From: Debra Cowling [REDACTED]
Sent: 12 August 2019 09:19
To: Zac Denton <Zac.Denton@arun.gov.uk>
Subject: Re: FG/65/19/HH - Extension of Time

As a result of an error during validation, this application has never been formally advertised. Are you able to agree to an Extension of Time until the 30th of August 2019?

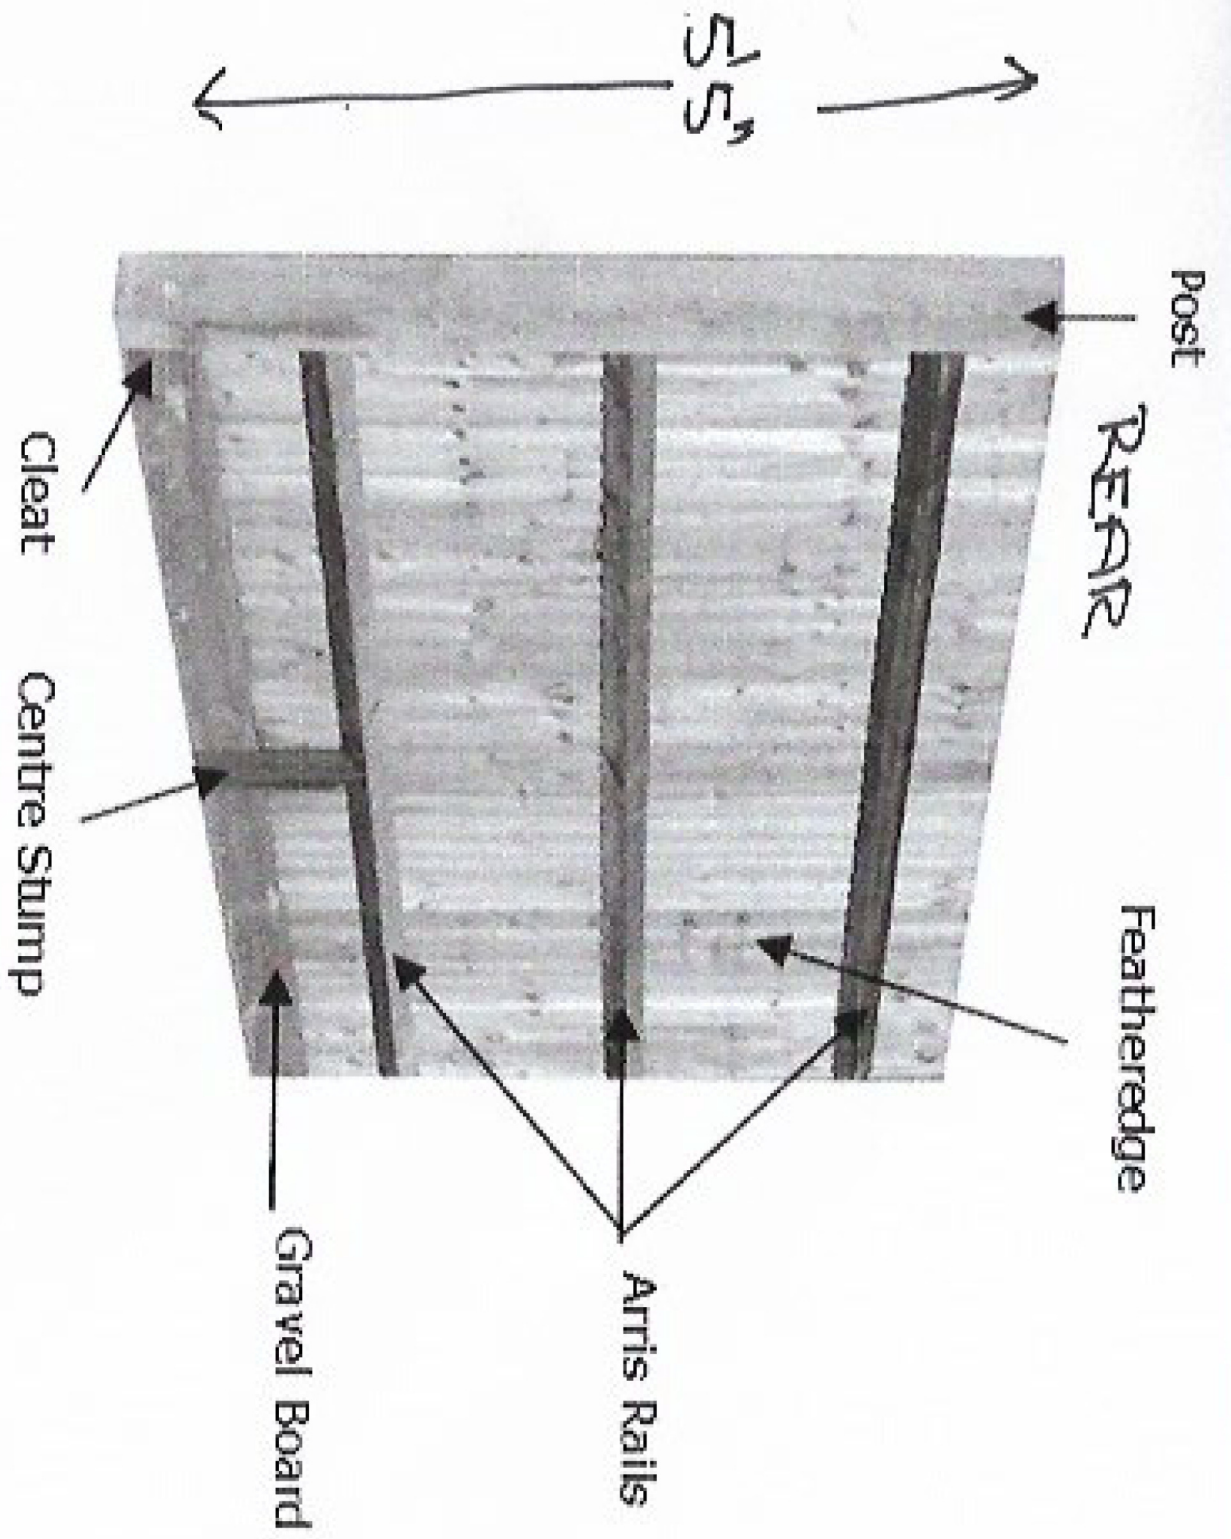
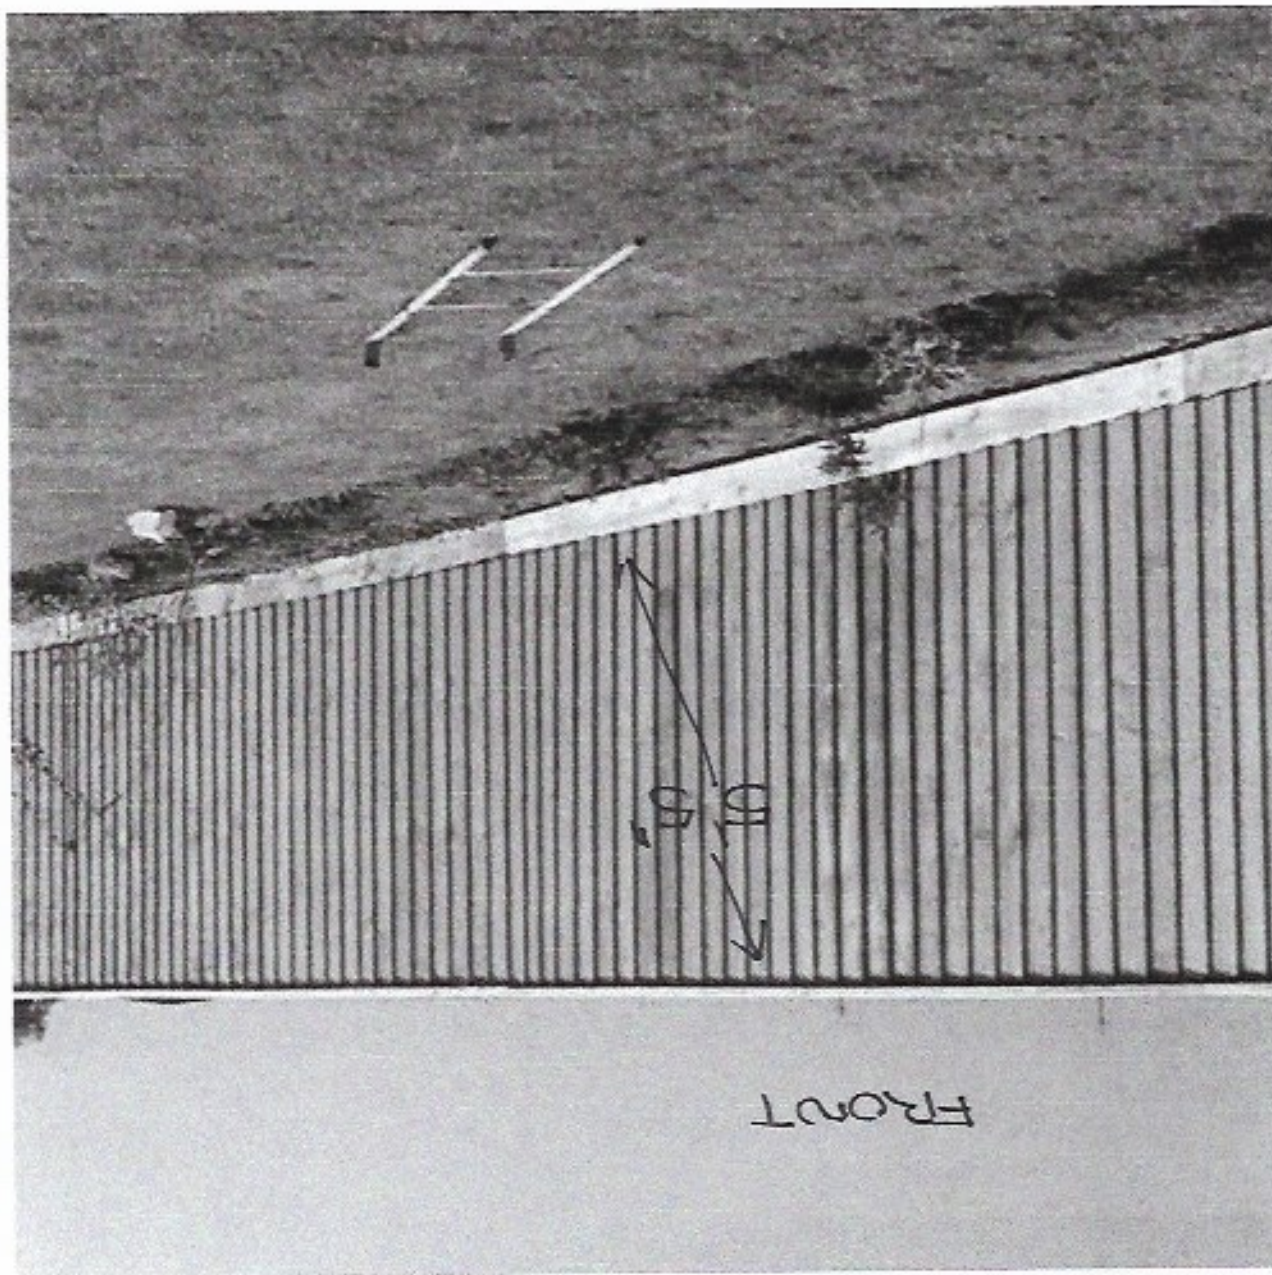
The plans appear to show that the fence is *behind* the hedging, as in, it will be visible within the street scene. Shown on the plan below:

Is the plan correct?

Very disappointed with this is there any way this can be fast tracked as we provisionally booked a fencer to start on the 19th. The fence will not be visible from West Drive as it behind exciting trees/bushs & on oval waye its only matching the neighbour opposite (same high) & all the neighbours we have spoken to all agree is will not be visible & i see on the website someone unknown to us sent a letter stating they cant see a problem with it . All we are trying to do is secure our garden & keep the dogs in and not cause anyone any problems
